Rezoning Transportation Analysis

Petition Number: 2022-216

Date	Description
05-24-2023	First Review (JP)
11-27-2023	Second Review (TP)
12-19-2023	Third Review (IW)

The site is located on the north side of Centergrove Lane, a State-maintained local street, west of Sam Wilson Road, a State-maintained minor thoroughfare. A Traffic Impact Study (TIS) is required for this site and was approved by CDOT on 11-27-2023. Site plan and/or conditional note revisions are needed including labeling and dimensioning right-of-way/curb and gutter elements from centerline.

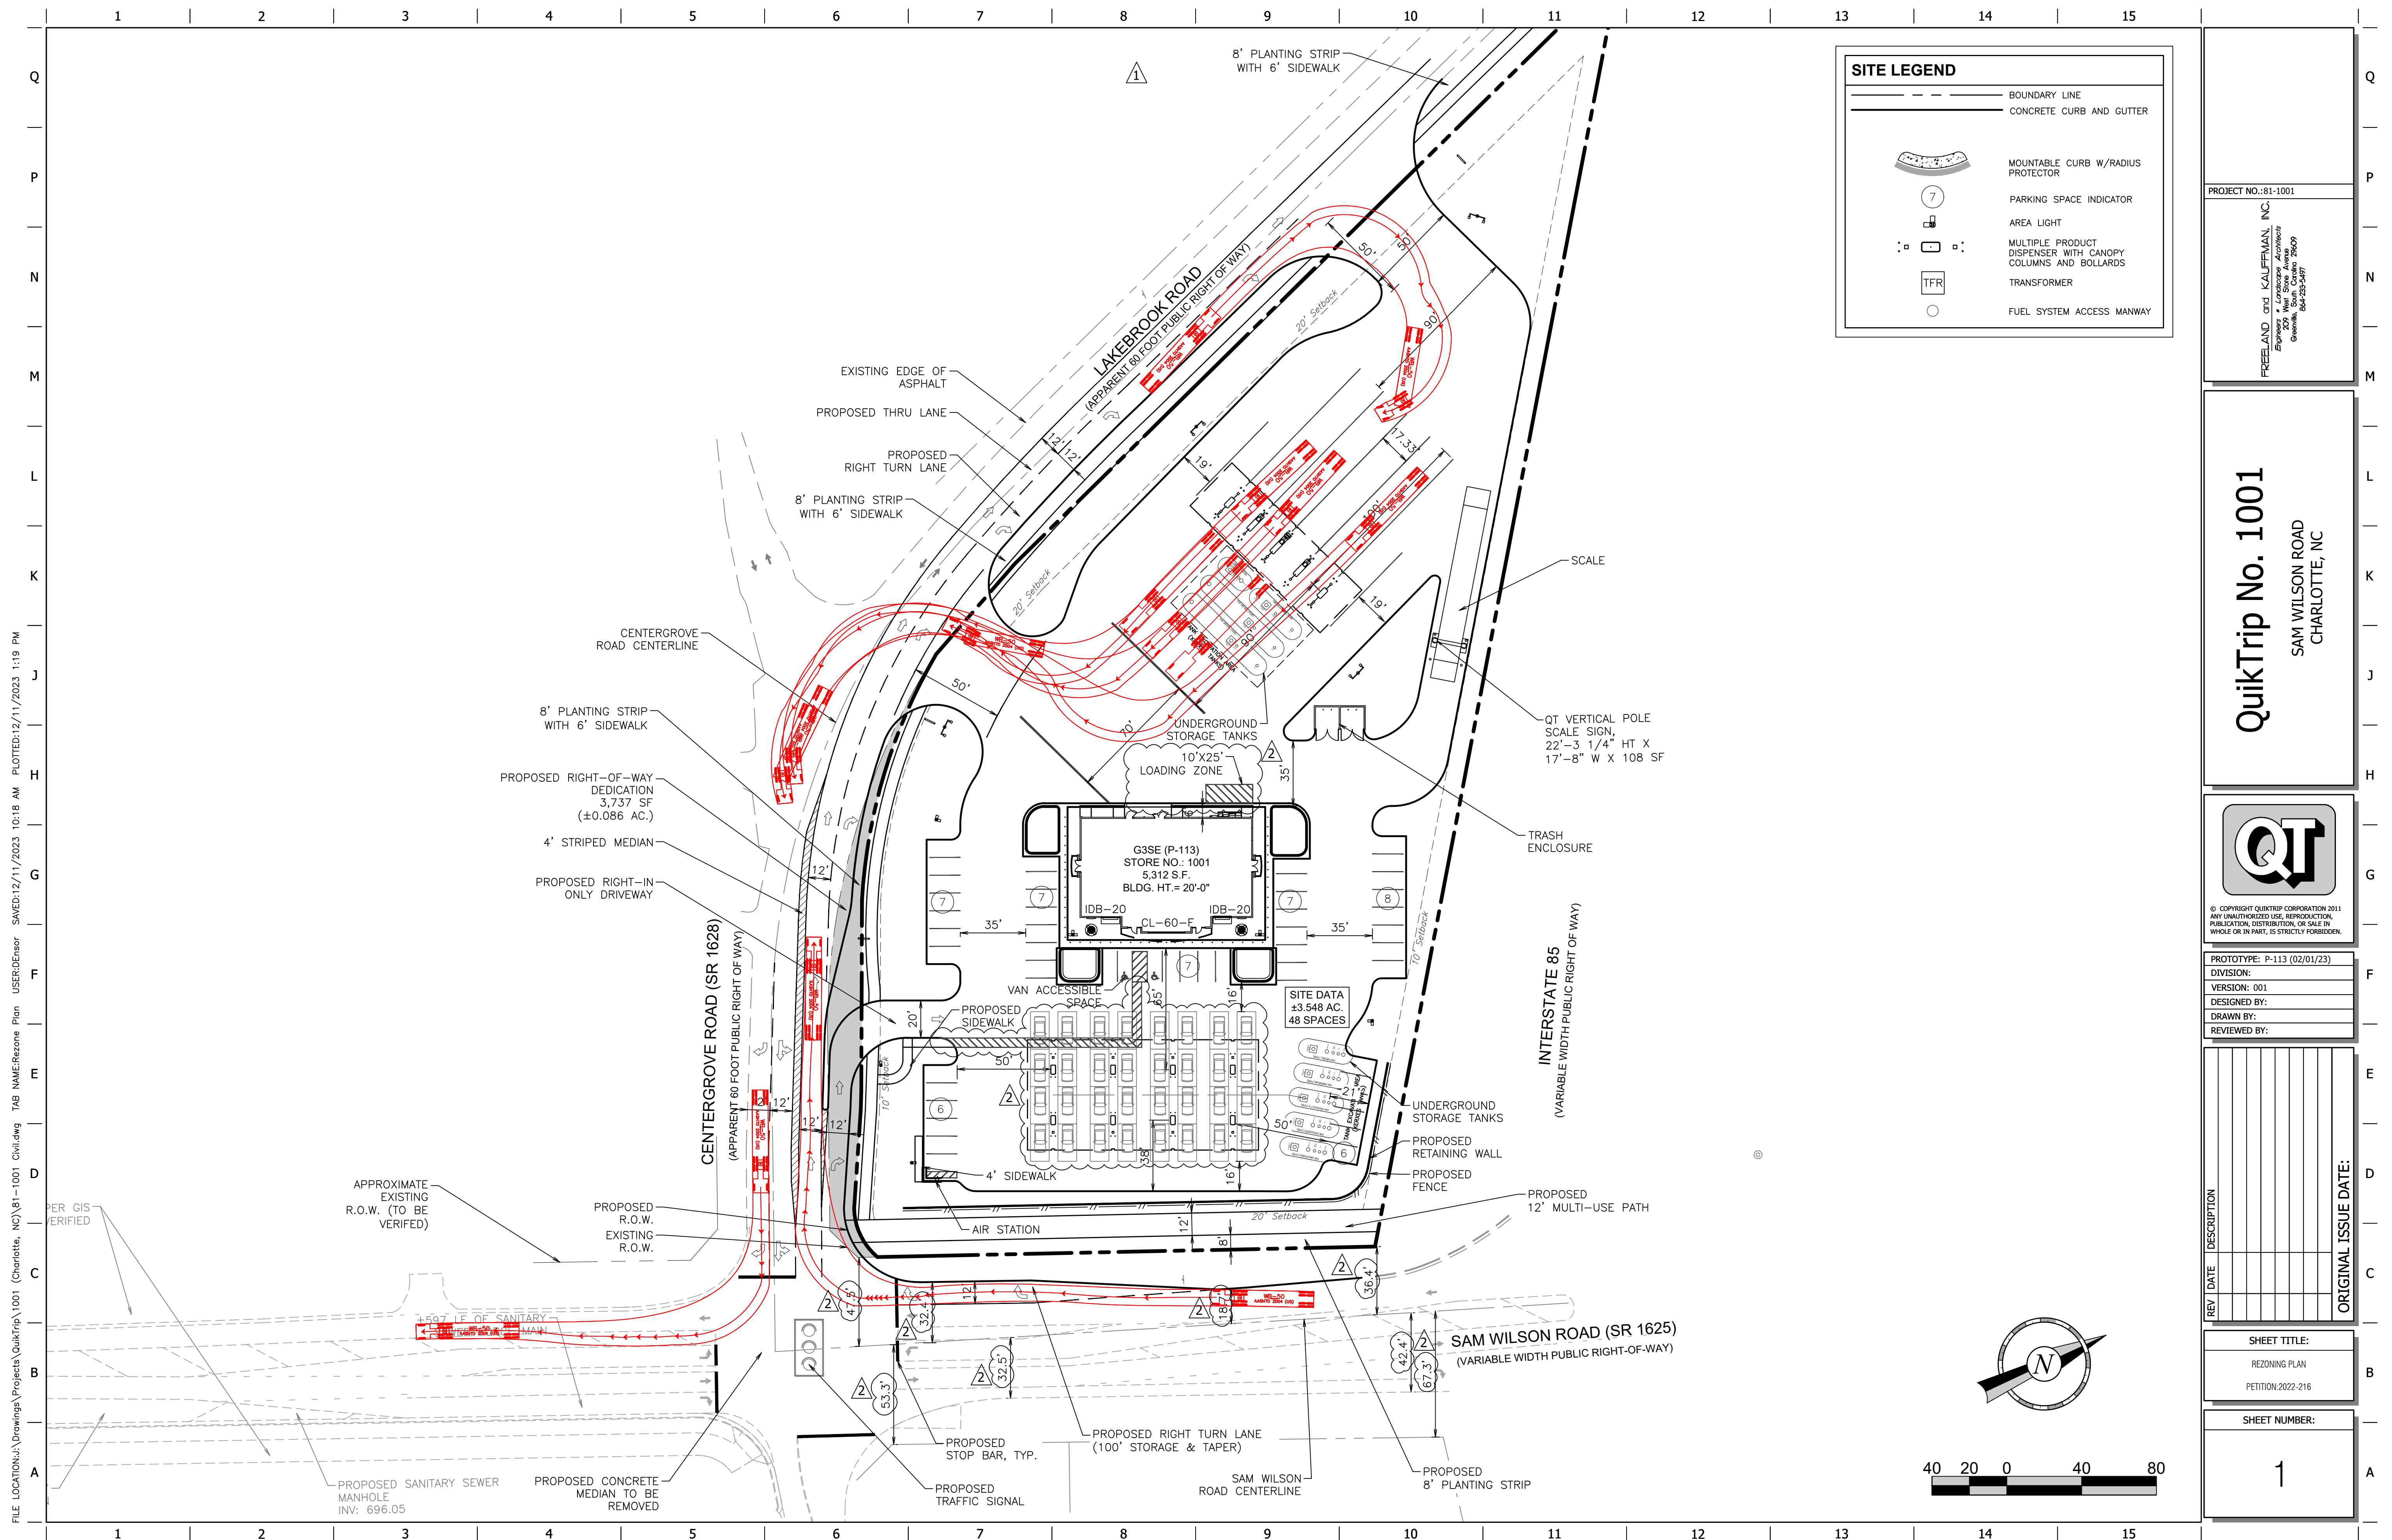
1. Curblines:

- Sam Wilson Road:** Location of curb and gutter to be moved to 30 feet from roadway centerline to accommodate the Charlotte Streets Map with a roadway typical section of a 4+ avenue with a 12-foot multi-use path.

Label and dimension the curb and gutter from the centerline for each road on the site plan.

Clarifying comment 11.27.2023: Label and dimension curb and gutter 30 feet from roadway centerline on Sam Wilson.

4. Revise site plan and conditional note(s) to commit to dedicate 35 feet of right-of-way from the road centerline on Sam Wilson Road. The site plan shall label and dimension the right-of-way from the road centerline.

Clarifying comment 11.27.2023: Label and dimension right-of-way from roadway centerline on Sam Wilson.

5. **New Comment 12-20-2023:** Revise site plan to clearly show and label where existing right of way is and proposed right of way.

12. Revise site plan and conditional note(s) to construct 8-foot planting strips and 6-foot sidewalks on Centergrove Lane and Lakebrook Road and a 12-foot multi-use path on Sam Wilson Road. The site

plan shall label and dimension both items from the back of curb and gutter or edge of pavement. Add conditional note The entire facility must be outside of the right of way and within a public access easement. Add conditional note committing to construction and maintenance of the 6-foot sidewalk on Centergrove Lane and the 12-foot multi-use path on Sam Wilson Road.

Clarifying comment 11.27.2023: Add conditional committing to maintenance of 6-foot sidewalk on Centergrove Lane.
